Andrew Hoath
38 Sherwood Road
Bersted
PO22 9DR

Please ask for: Rhiannon Lloyd
Email: rhiannon.lloyd@arun.gov.uk
Telephone: 01903 737637
Our Ref: BE/80/24/PDH
Your Ref:
Date: 23rd September 2024

Prior Notification for a Permitted Development (Householder)

Development: Notification under extended permitted development rights for a single storey rear extension measuring 4 metres from beyond the rear wall of the dwellinghouse, with a maximum height of 3.5 metres and an eaves height of 2.8 metres.
Location: 38 Sherwood Road Bersted PO22 9DR

PROPOSED ELEVATIONS.

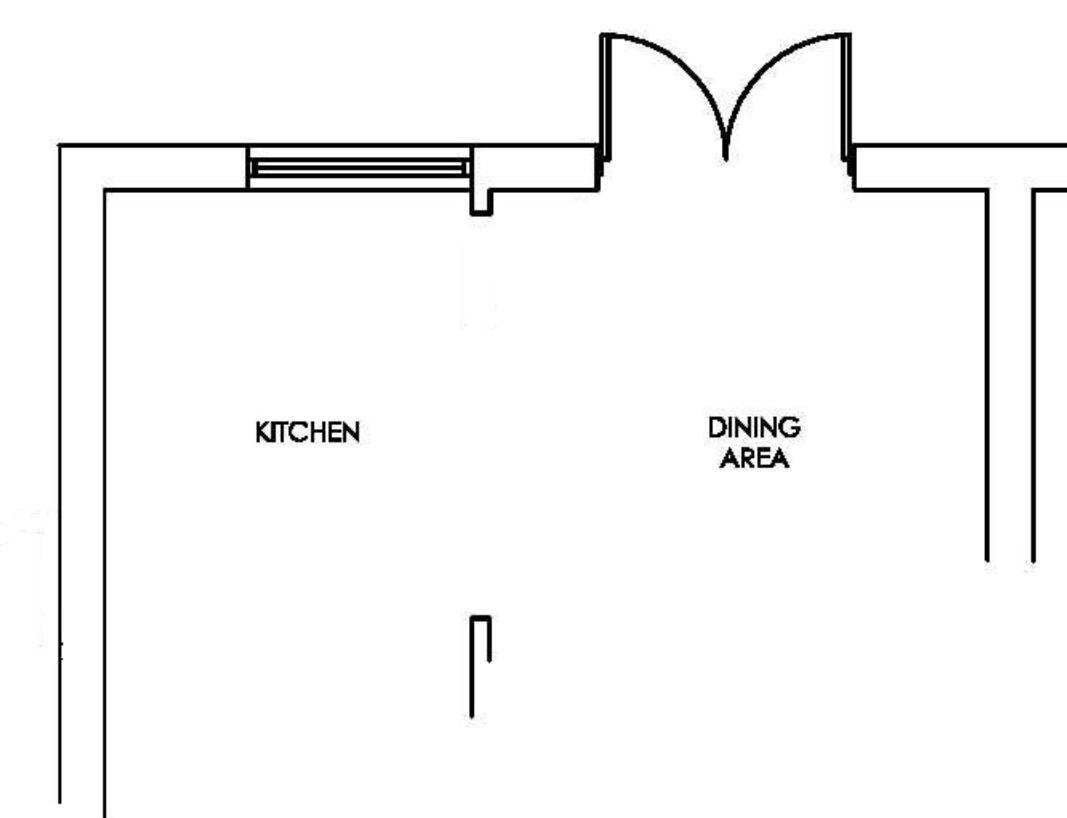
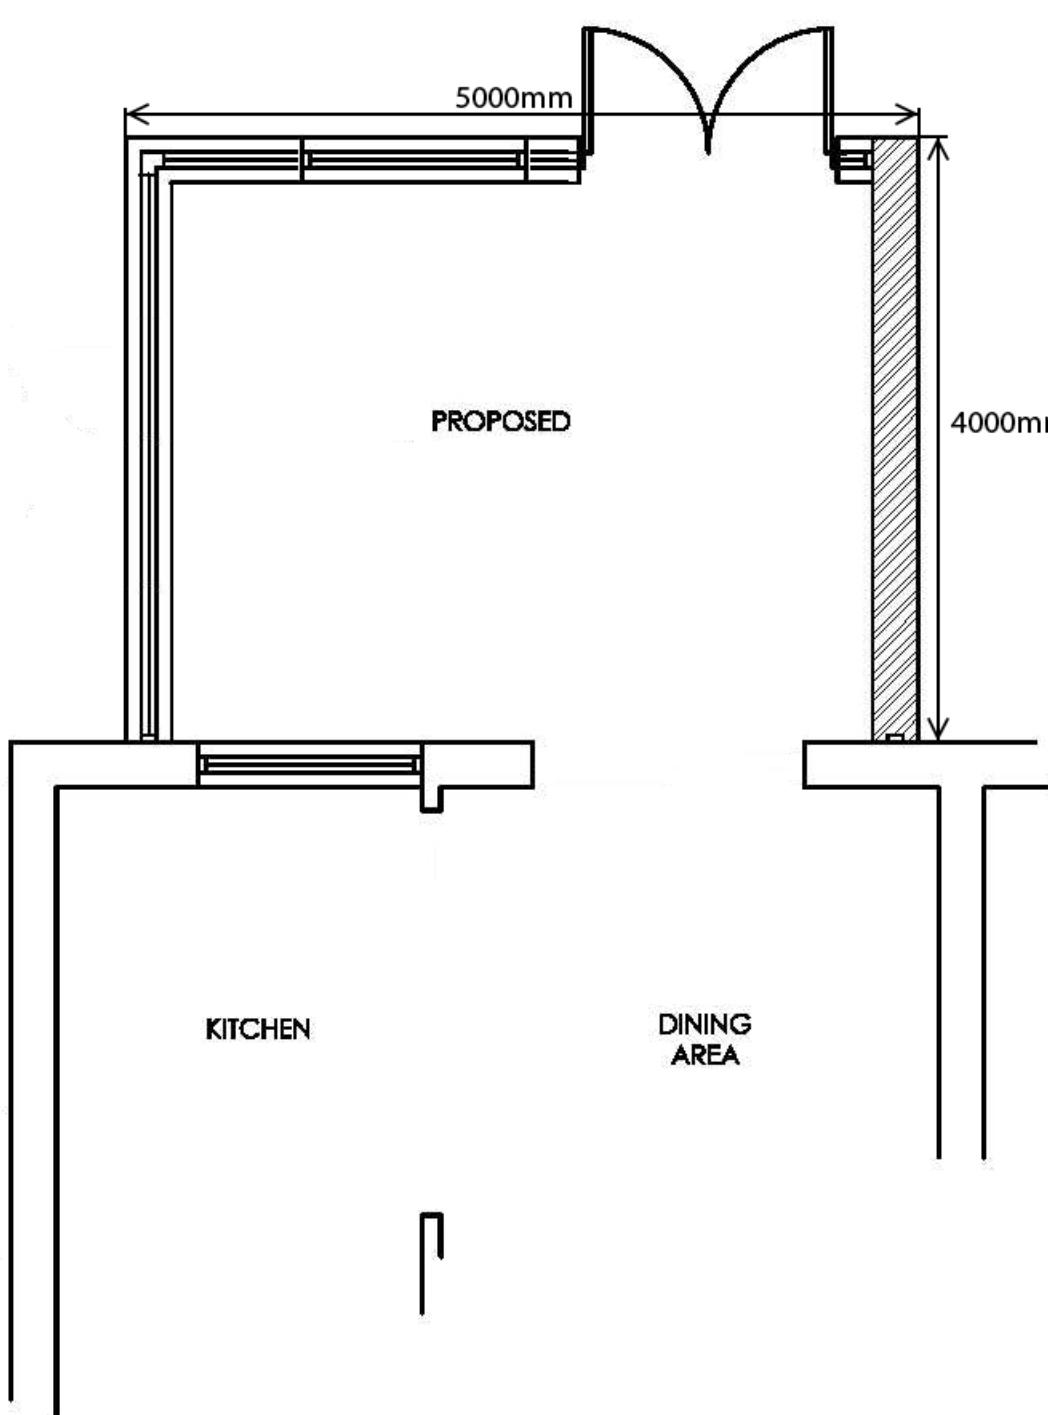
Please provide an amended plan sheet indicating the proposed height of the extension, as well as the length and width already shown.
